**Consultation Response from Mike Hibbert,
KC Waste Strategy(Refuse & Recycling)**

2023/92145 East Bierley Playing Fields, Hunsworth Lane, East Bierley, BD4 6PU

Discharge of conditions 5 (access track upgrade), 6 (access track upgrade), 7 (cycle parking), 8 (electric vehicle charging), 9 (travel plan), 10 (waste storage and collection), 11 (coal mining investigation), 16 (Japanese Knotweed strategy), 17 (external lighting), 29 (landscaping) and 30 (biodiversity enhancement and management plan) of previous permission 2021/90357 for works to existing sports facilities including erection of clubhouse; additional changing facilities building; boundary treatments; storage facilities and floodlighting; works to existing pitches creation of hybrid and 3G/synthetic pitches; multi sport training area and car park

Date Responded: 26/07/2023.

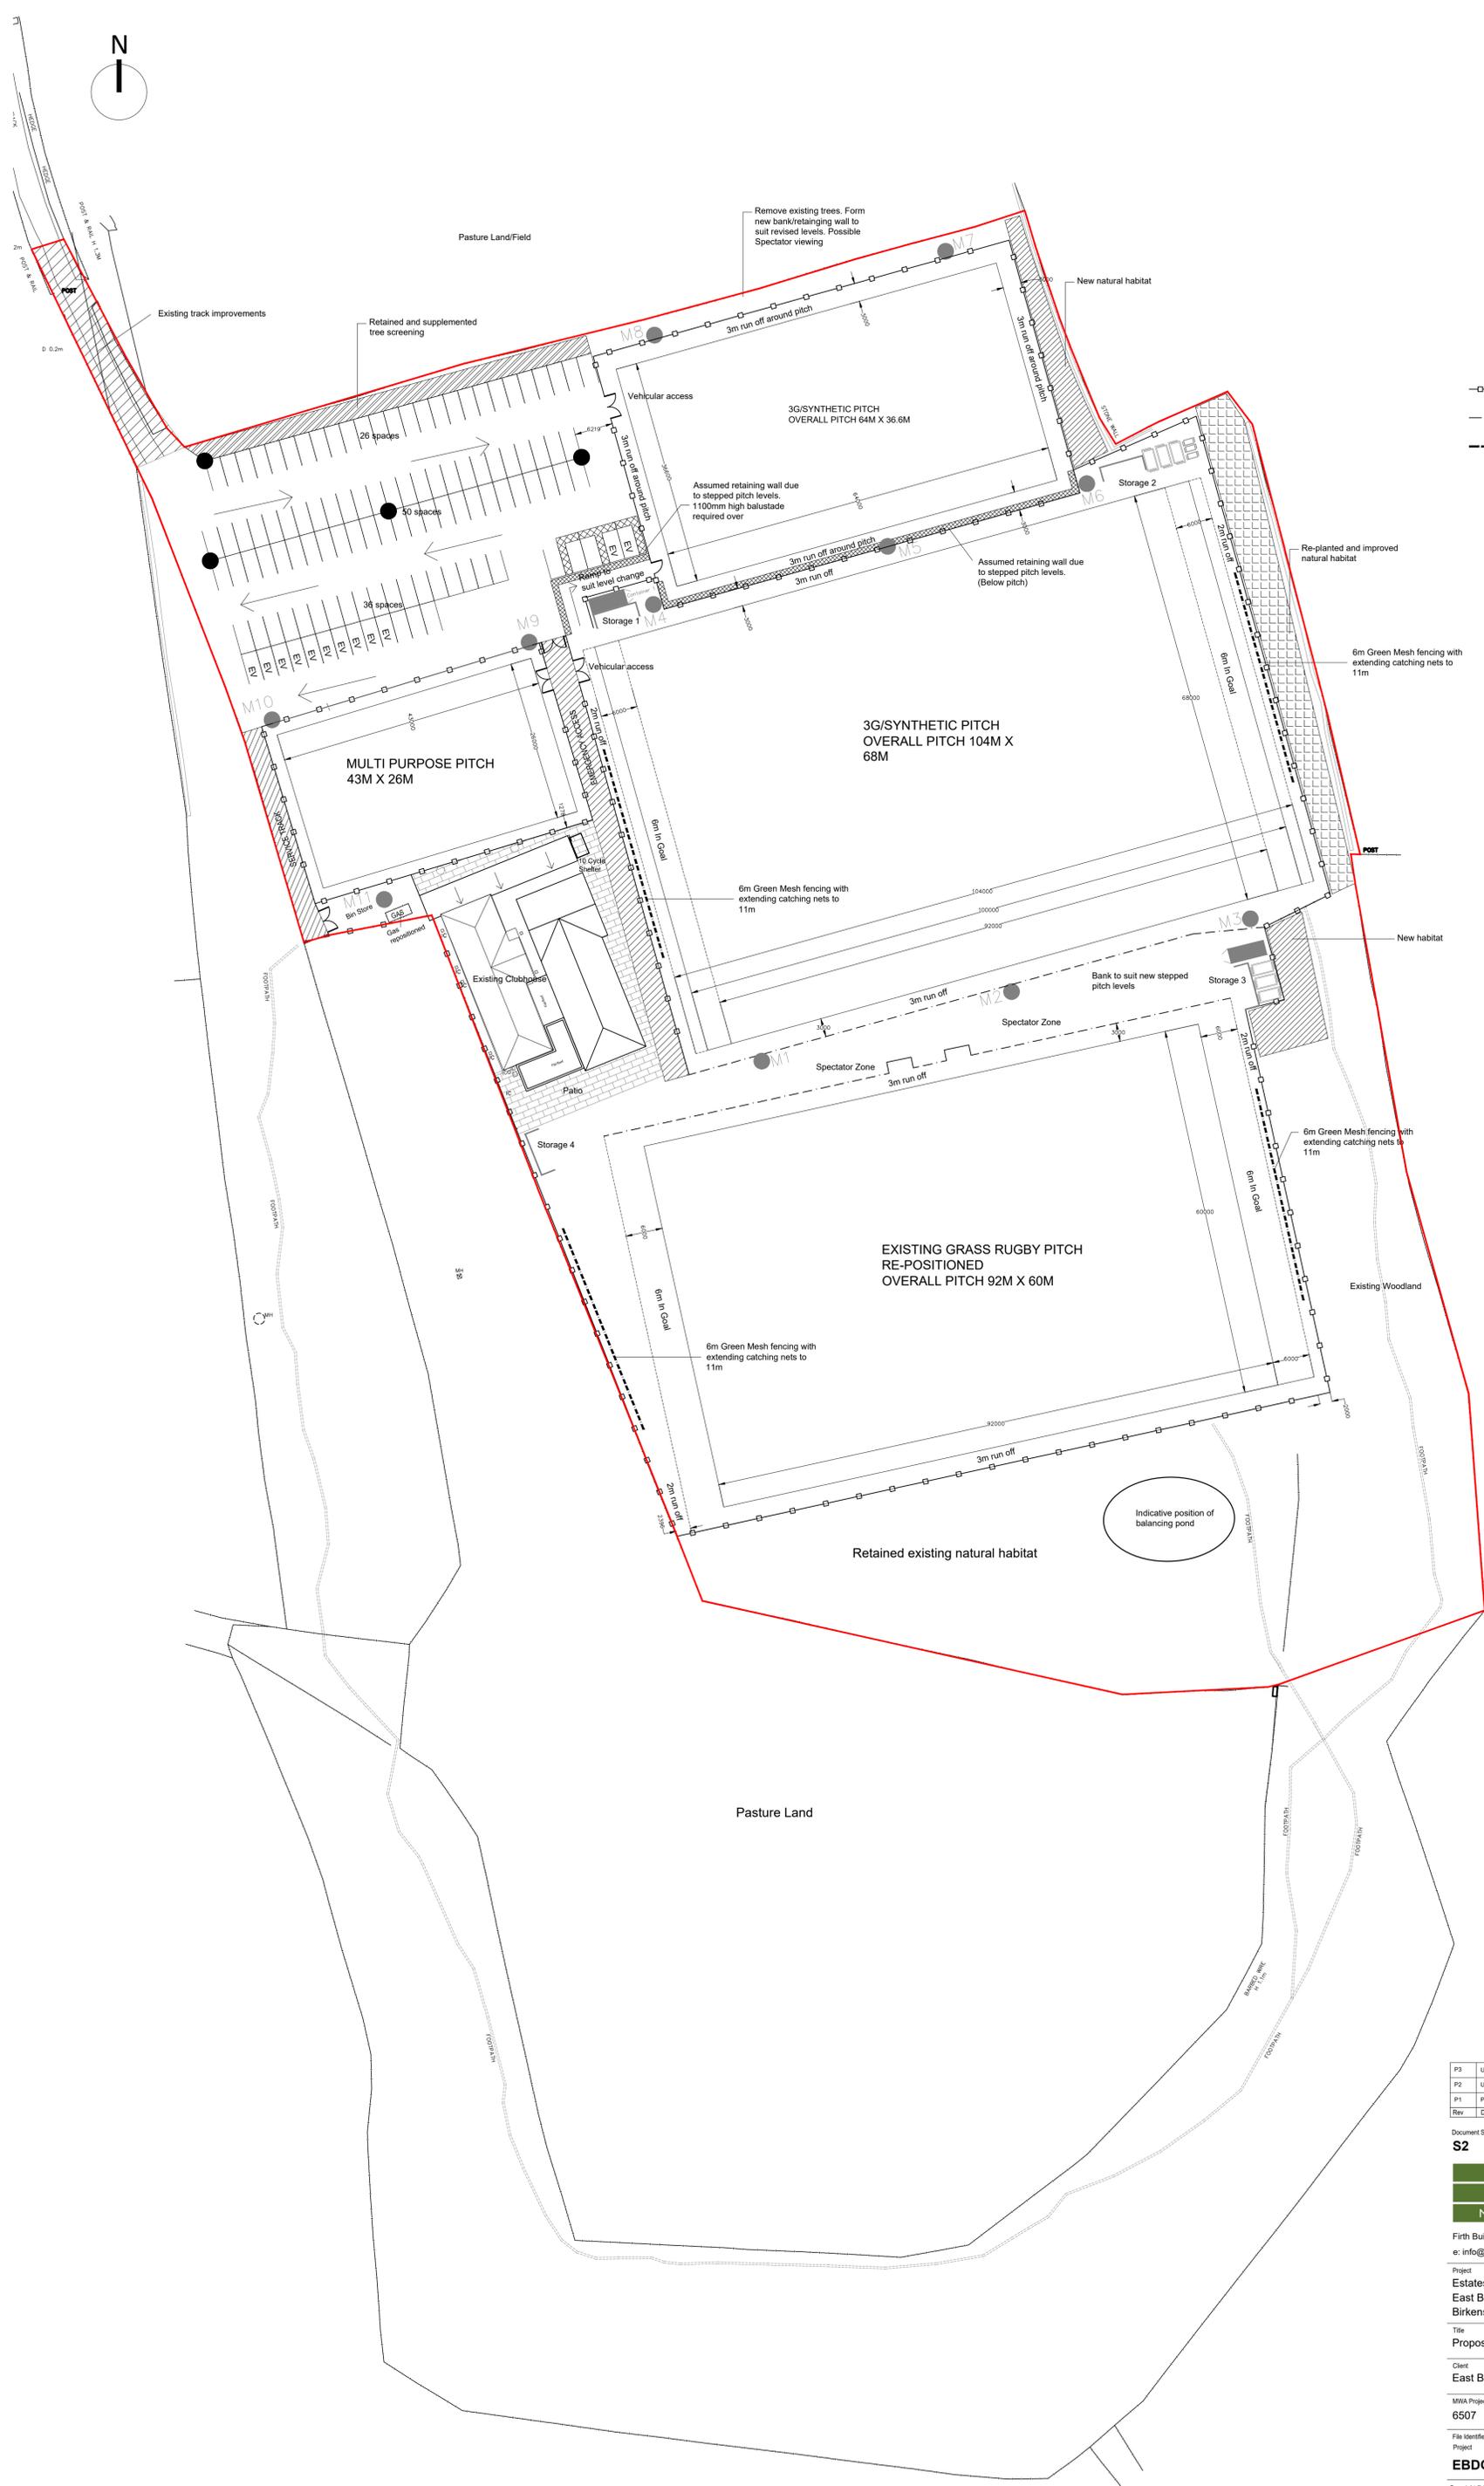
The applicant has submitted Site Plan EBDC-MWA-XX-XX-DR-A_0001_P5 dated 22/6/23 which shows the location of the proposed Bin Store within the car park area. This will allow for access for a refuse vehicle which can enter and leave the site in a forward motion. The bin store is to be an enclosed secure timber frame with horizontal boards as per the below comprising:

- An open top to allow ventilation and prevent odours
- Double lockable gates for security
- 2100mm high

The Waste Collection Authority can confirm that the proposals are satisfactory, and that Condition 10 can be discharged.
